# ROLLING HILLS RANCH NORTH FILING NO. 1 AT MERIDIAN RANCH

# V1\_Final Plat Drawings.pdf Markup Summary

TRACT A
5.632 AC.

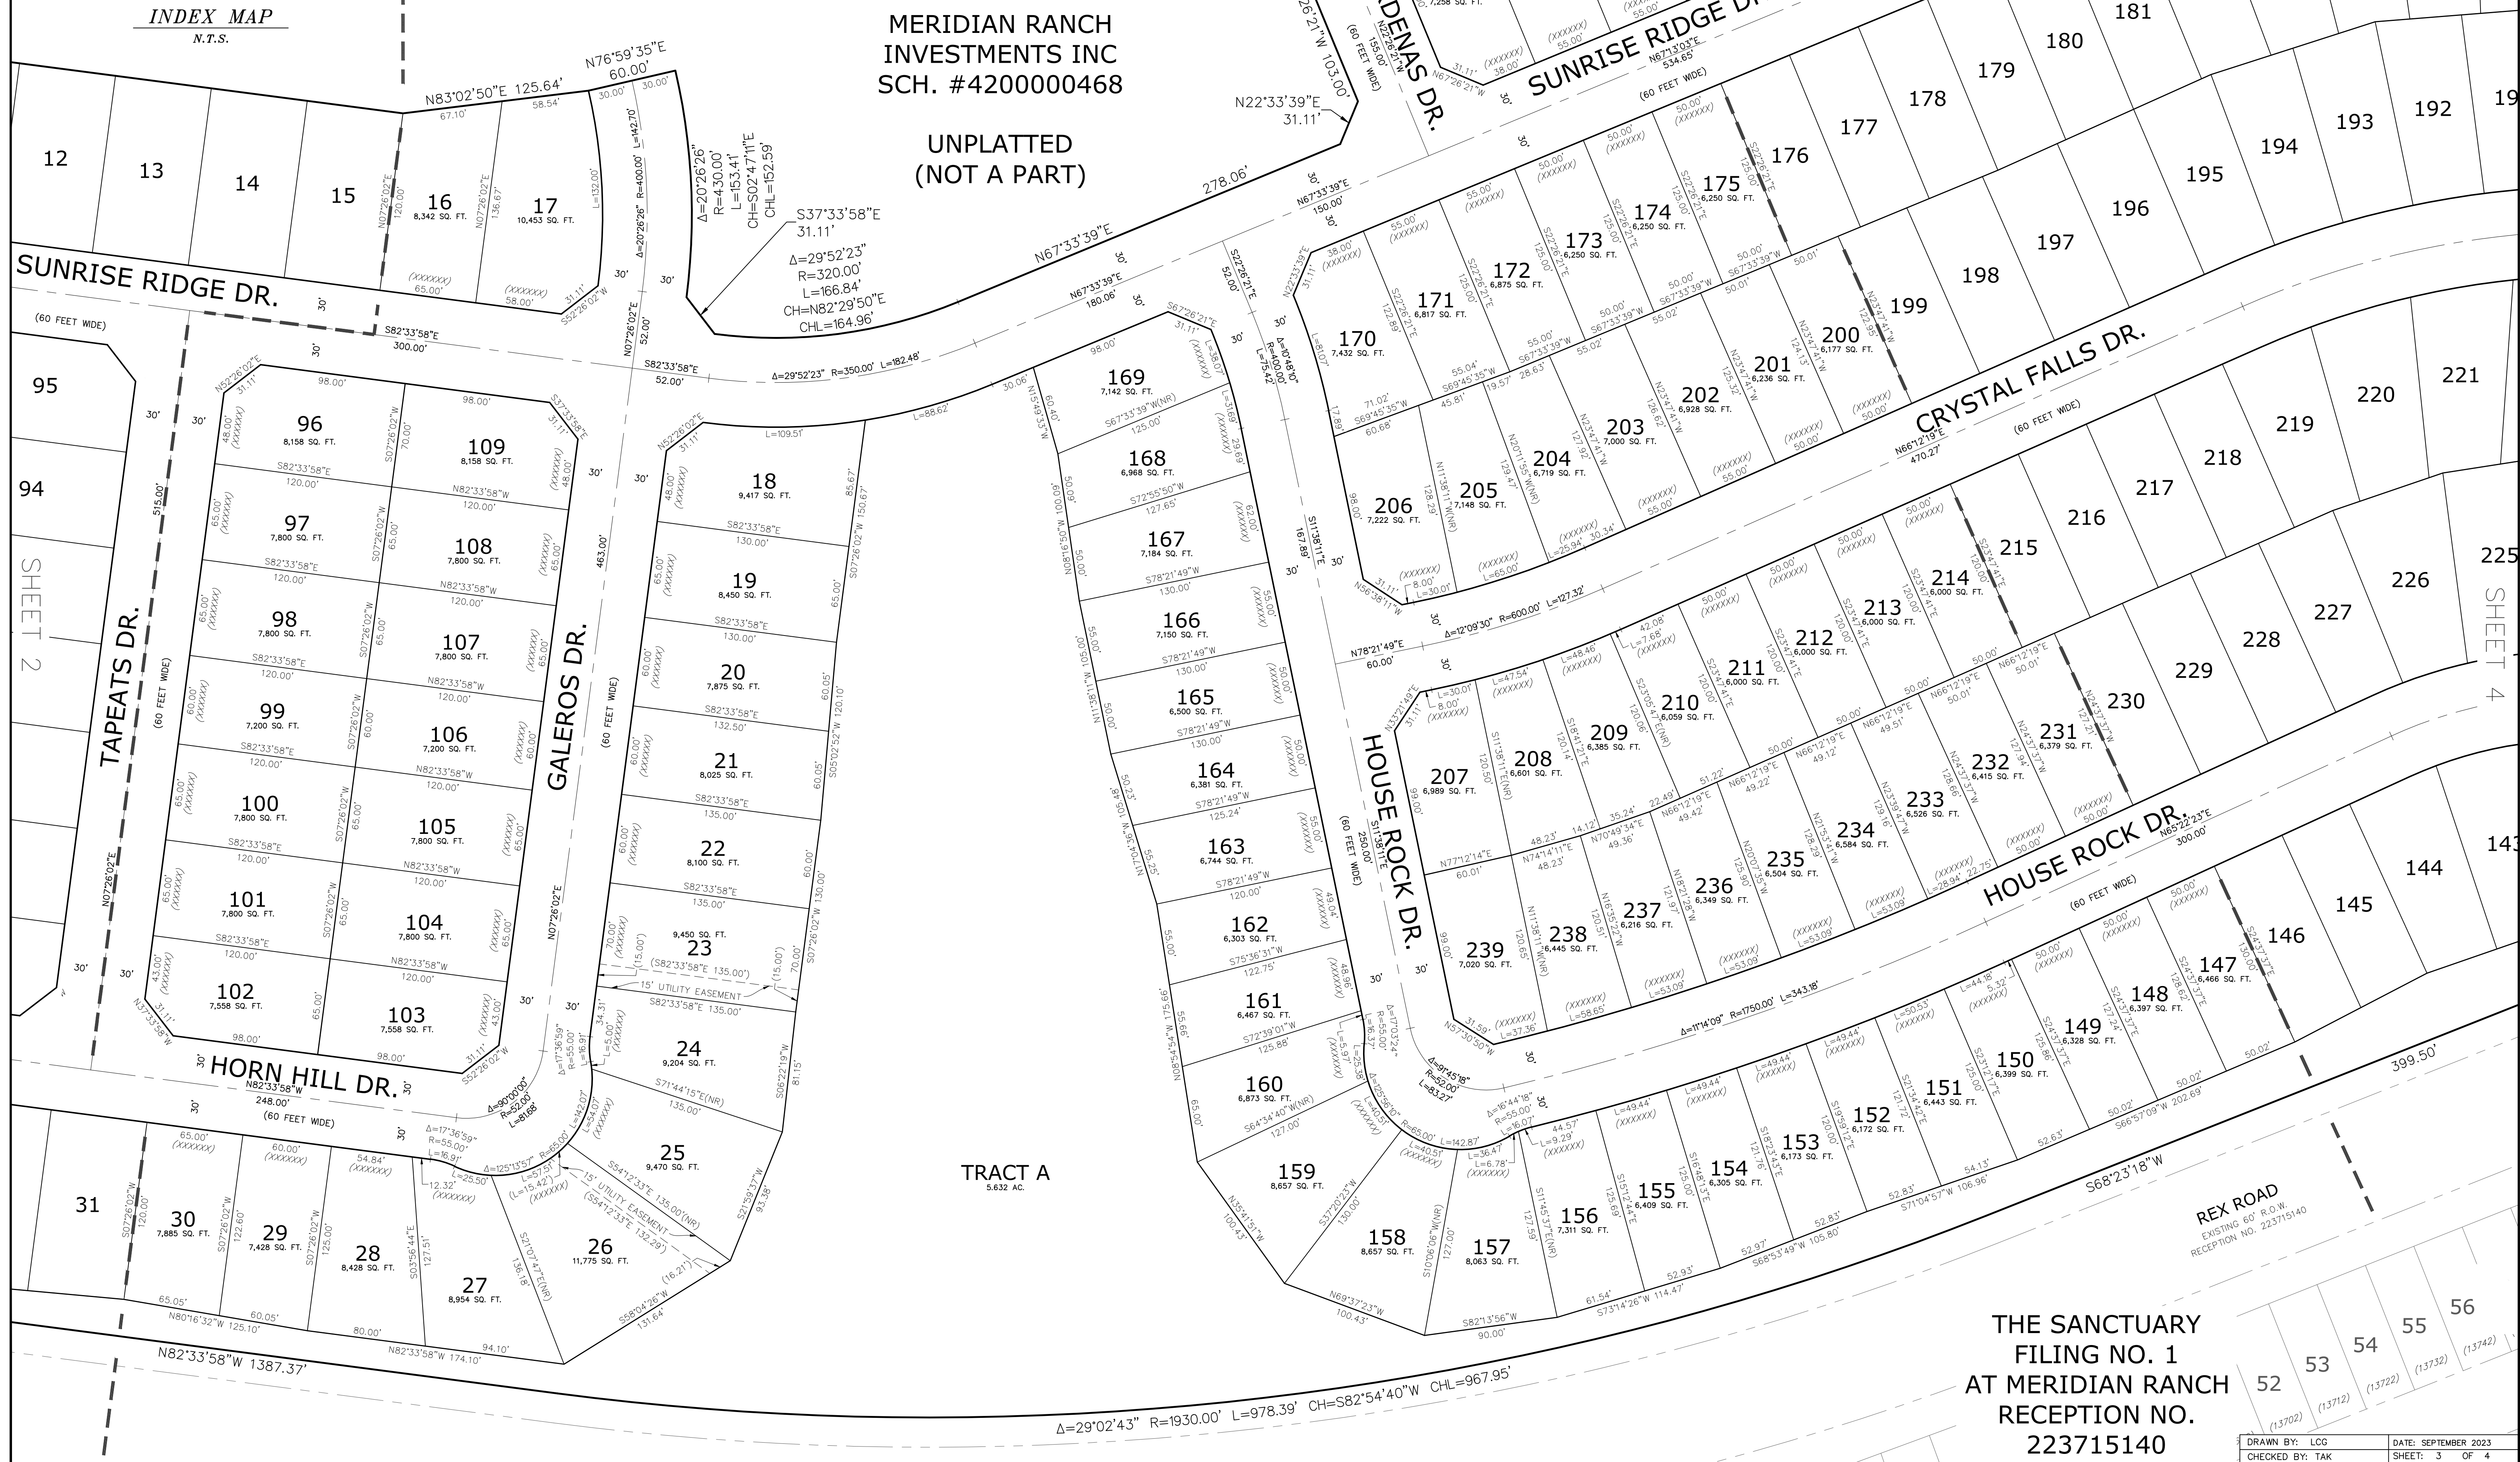
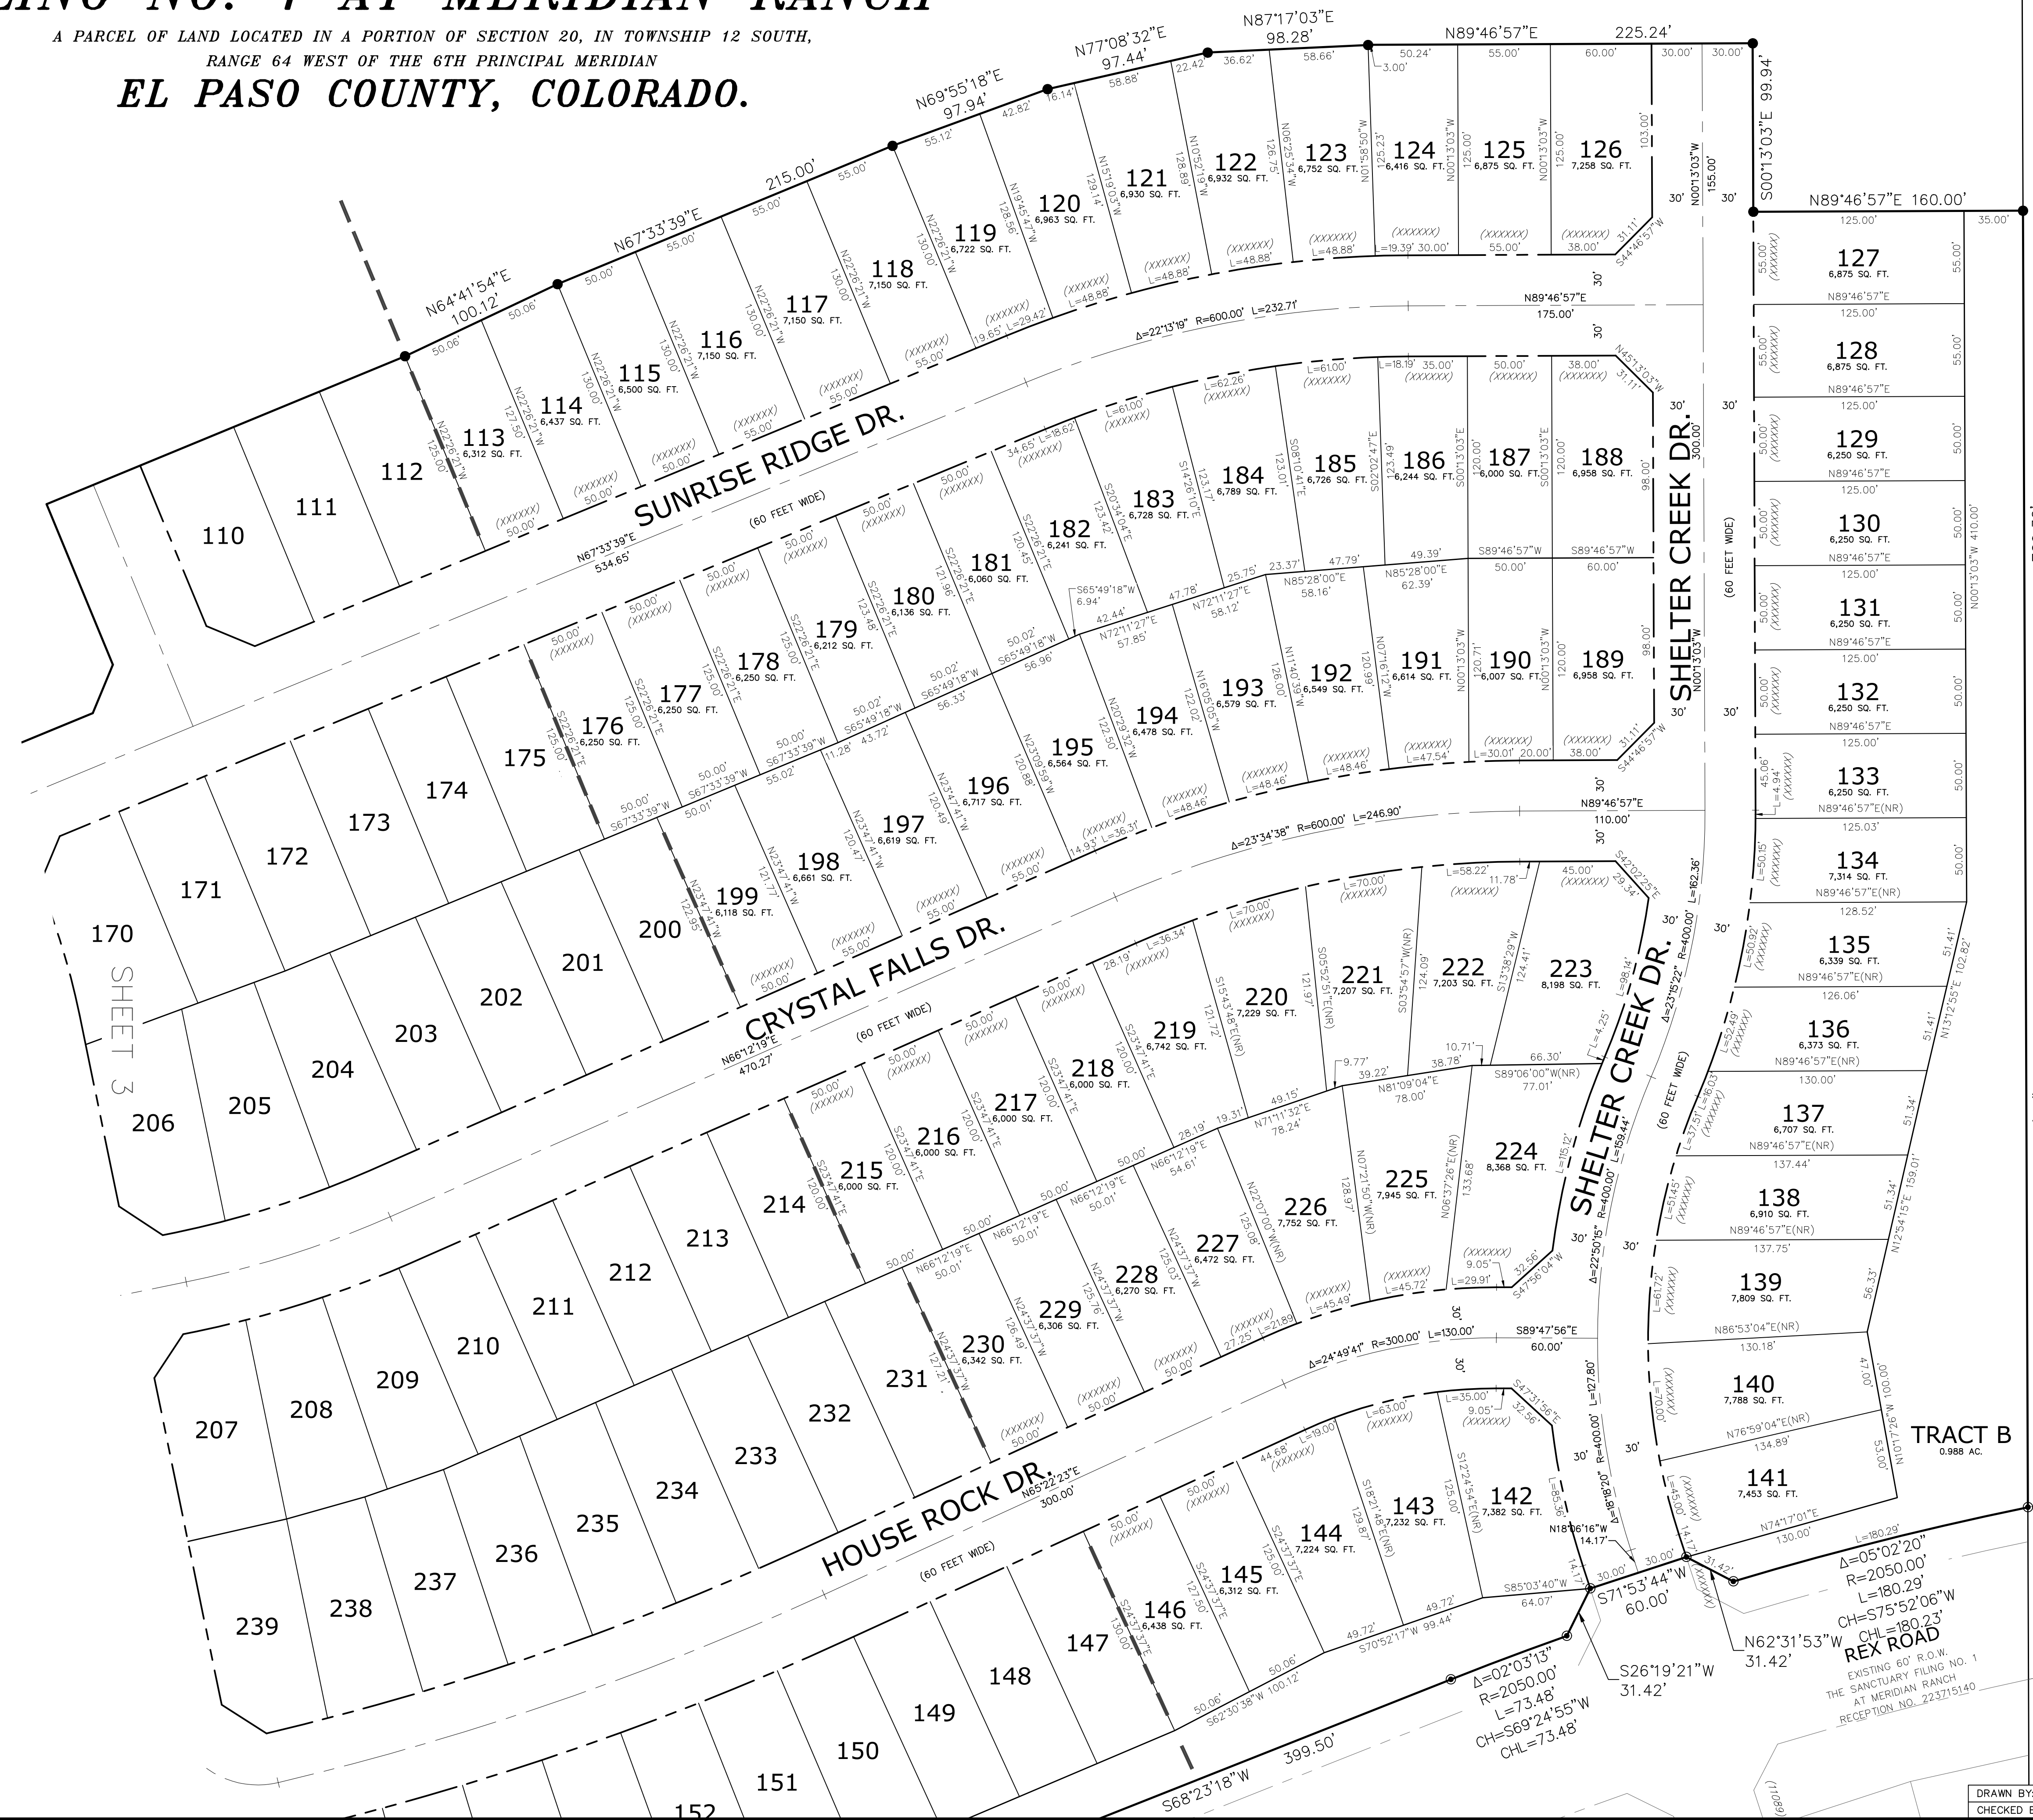
Add Driveway Note:  
Individual lot purchasers are responsible for constructing driveways, including any necessary drainage culverts per Land Development Code Section 6.3.3.C.2 and 6.3.3.C.3.

Add these notes:

Tract \_\_\_\_\_ shall be utilized as \_\_\_\_\_ (park, neighborhood park, school site, fire station, drainage tract, etc). Ownership and maintenance of Tract \_\_\_\_\_ shall be vested to (name the entity: El Paso County, Special District, Homeowners Association, etc.) (Where multiple tracts are included in a single PUD plan or plat, the use of a tract table is encouraged.)

Lot \_\_\_\_ (or Tract \_\_\_\_ ) (or entire property) of this property is subject to a Private Detention Basin/Stormwater Quality BMP Maintenance Agreement and Easement as recorded at Reception No. \_\_\_\_\_ of the records of El Paso County. The \_\_\_\_\_ HOA (or Owner or District) is responsible for maintenance of the subject drainage facilities.

Please include the following note:

El Paso County does not own and is not responsible for the underdrains or groundwater discharge systems. Maintenance and water rights are the responsibility of the developer and \_\_\_\_\_ [ xx metropolitan district, yy property owner's association ]

Replace Note 2:  
There shall be no direct lot access to \_\_\_\_\_ Road.

All property owners are responsible for maintaining proper storm water drainage in and through their property. Public drainage easements as specifically noted on the plat shall be maintained by the individual lot owners unless otherwise indicated. Homebuilders are responsible to ensure proper drainage around structures, including elevations of foundations and window wells in relation to side-lot drainage easements and swales. Homeowners shall not change the grade of the lot or drainage swales within said easements, as constructed by the builder, in a manner that would cause adverse drainage impacts to properties. Structures, fences, materials or landscaping that could impede the flow of runoff shall not be placed in drainage easements.

Include the 1/4 section

The following note shall be placed on the plat: "Any person who knowingly removes, alters or defaces any public land survey monument or land boundary monument or accessory commits a Class Two (2) misdemeanor pursuant to C.R.S. § 18-4-508"

Delete this note - it is covered under Note 20

Delete this note and replace with the proposed note below for tract maintenance

This note is not necessary for subdivisions which utilize central services

Add to Note 12:  
 Geologic Hazard Note-Final Plat: (to be customized based upon the individual circumstances)  
 The following lots have been found to be impacted by geologic hazards. Mitigation measures and a map of the hazard area can be found in the report (Title of Report, generally from the Preliminary Plan file) by (author of the report) (date of report) in file (name of file and file number) available at the El Paso County Planning and Community Development Department:

Replace Note 5:  
 Water and wastewater service for this subdivision is provided by the \_\_\_\_\_ (District or provider name(s)) subject to the District's (Providers) rules, regulations and specifications.

Replace Note 24:

All property within this subdivision is within the boundaries of the Woodmen Road Metropolitan District and, as such, is subject to a mill levy, platting fees and building permit fees for the purpose of financing construction of specified improvements to Woodmen Road.

Identify in the road labels whether these are public or private right-of-way
